**EL PASO COUNTY PLANNING AND
 COMMUNITY DEVELOPMENT
 DEPARTMENT**

GRADING AND EROSION CONTROL PLAN CHECKLIST

STORMWATER MANAGEMENT PLAN CHECKLIST

GEC6

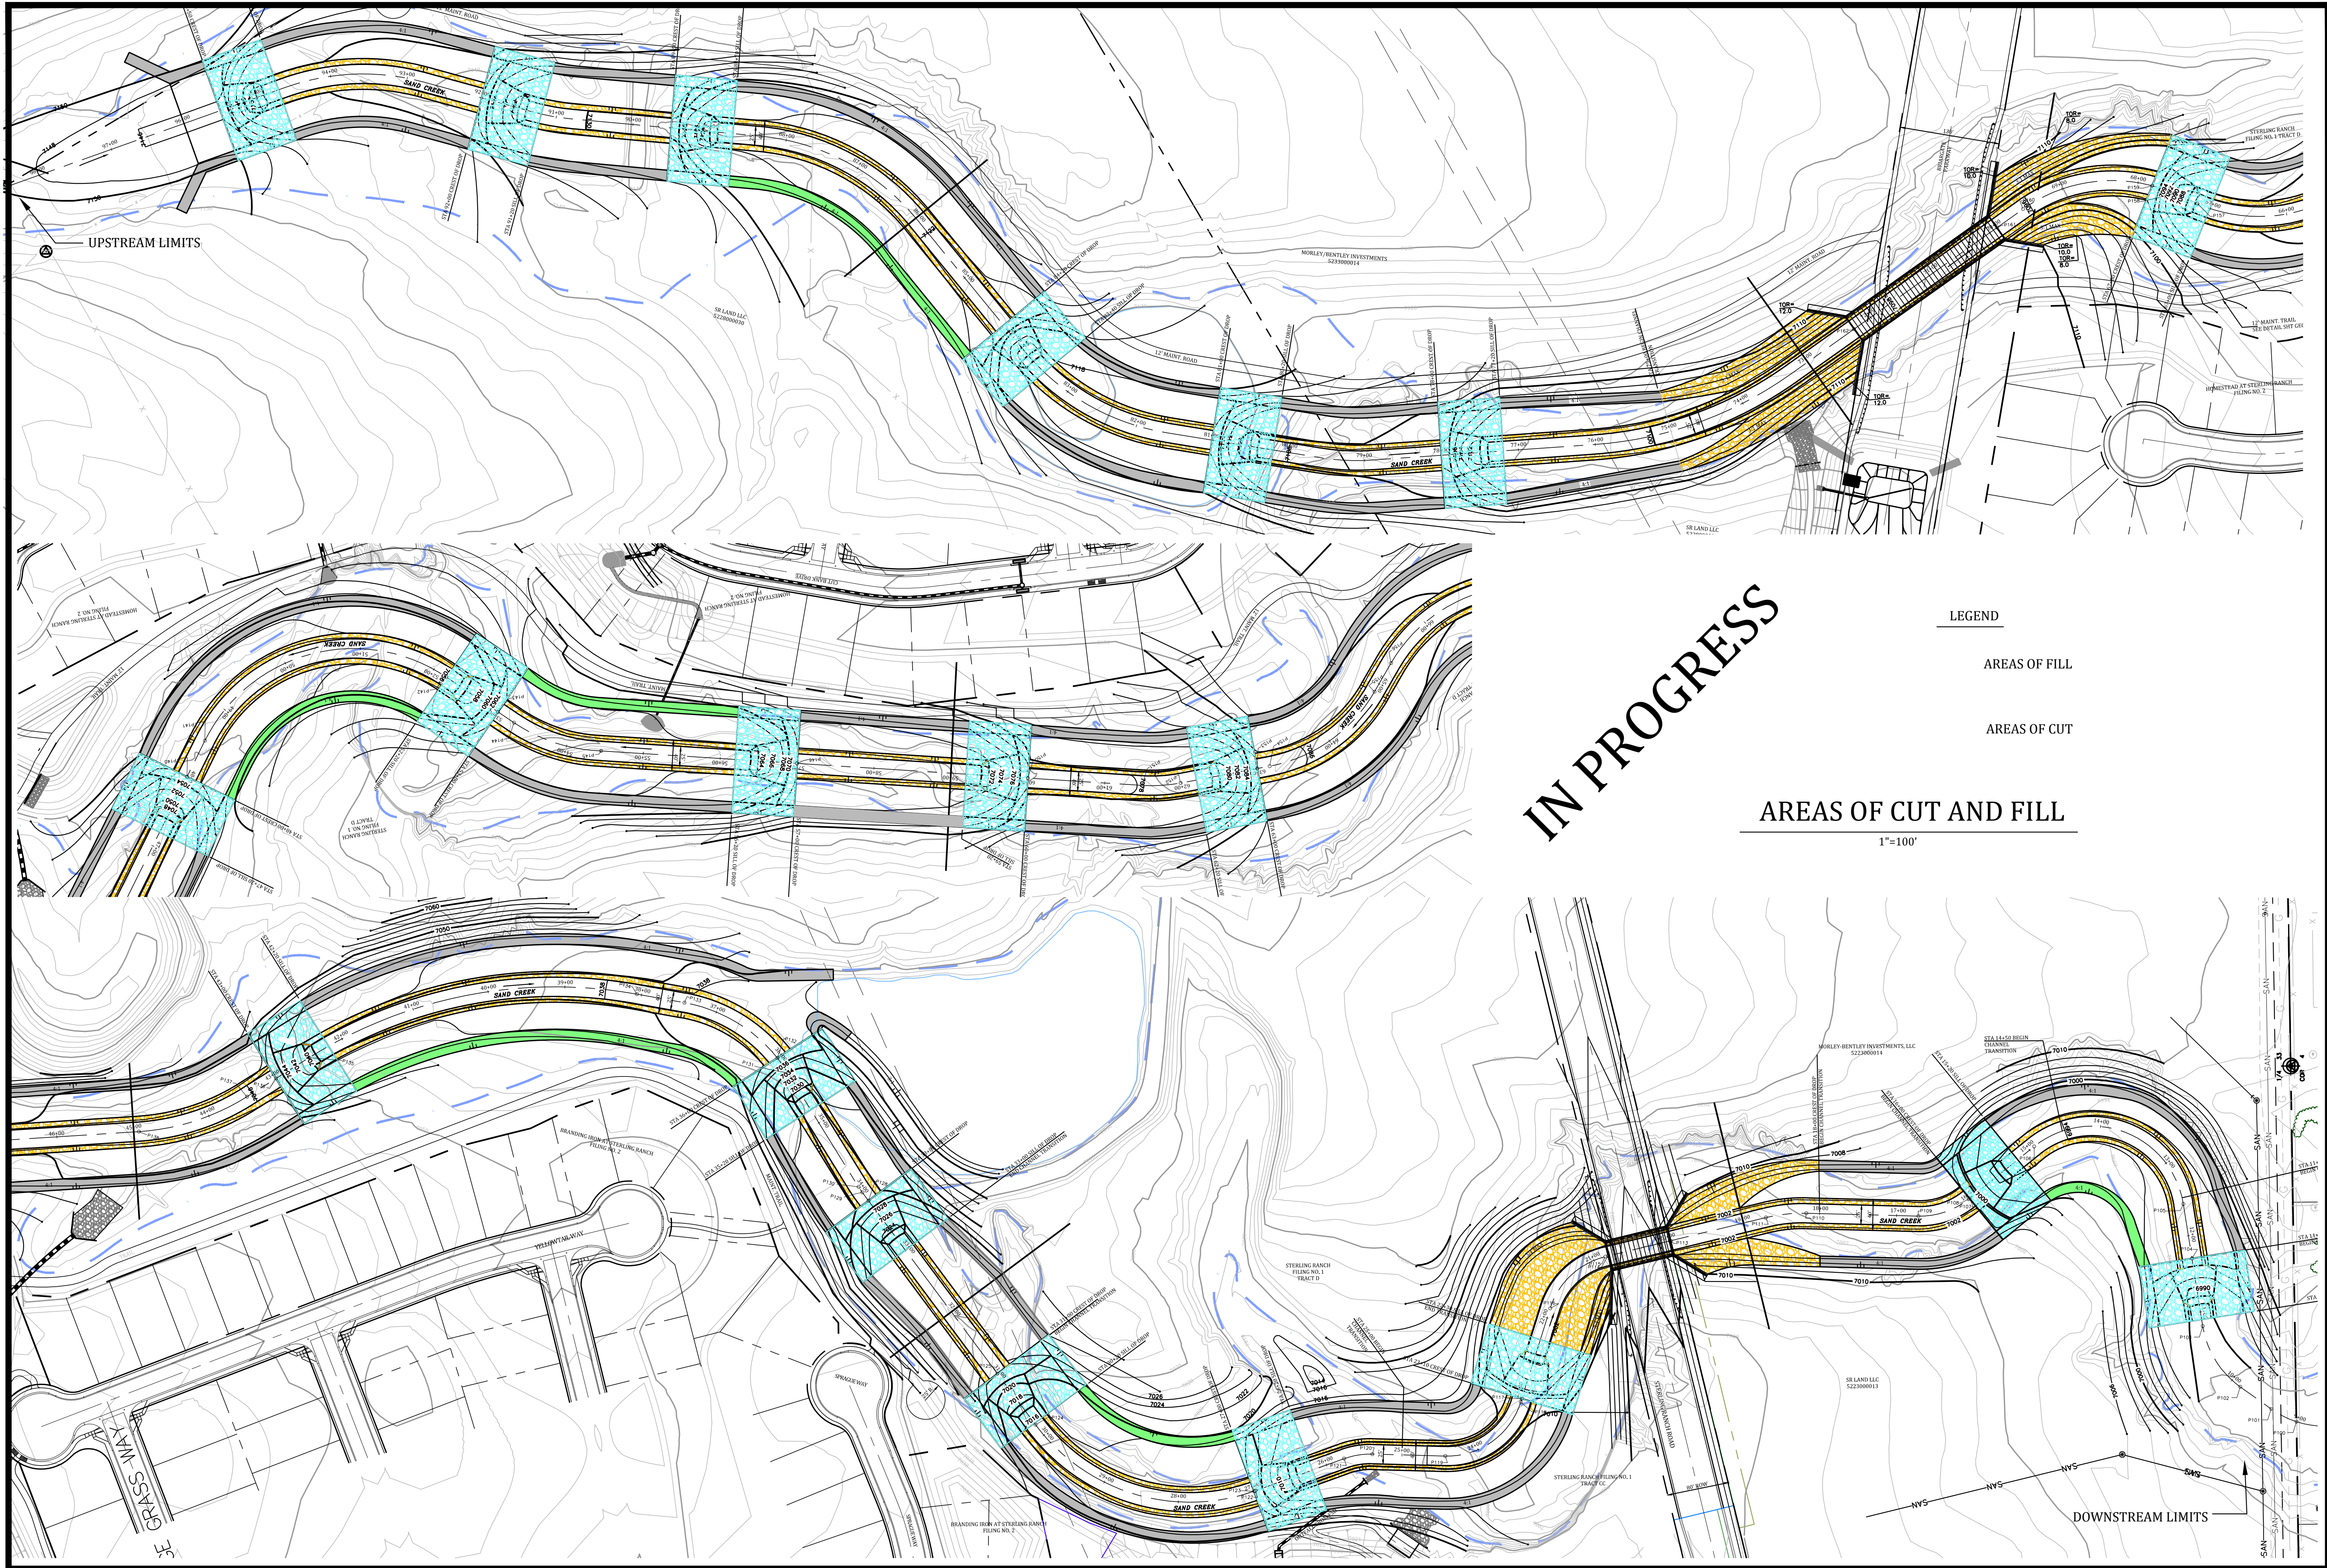
Revised: July 2019		Applicant	PCD
17	SWMP Map to include: Comments provided on CDs	X	
17a	construction site boundaries	X	✓
17b	flow arrows to depict stormwater flow directions	X	✓
17c	all areas of disturbance	X	✓
17d	areas of cut and fill	X	X
17e	areas used for storage of building materials, soils (stockpiles) or wastes	X	✓
17f	location of any dedicated asphalt / concrete batch plants	X	✓
17g	location of all structural control measures show proposed offsite VTC locations	X	X
17h	location of all non-structural control measures	X	✓
17i	springs, streams, wetlands and other surface waters, including areas that require maintenance of pre-existing vegetation within 50 feet of a receiving water	X	✓
18	Narrative description of all structural control measures to be used. Modifications to EPC standard control measures must meet or exceed County-approved details.	X	✓
19	Description of all non-structural control measures to be used including seeding, mulching, protection of existing vegetation, site watering, sod placement, etc.	X	✓
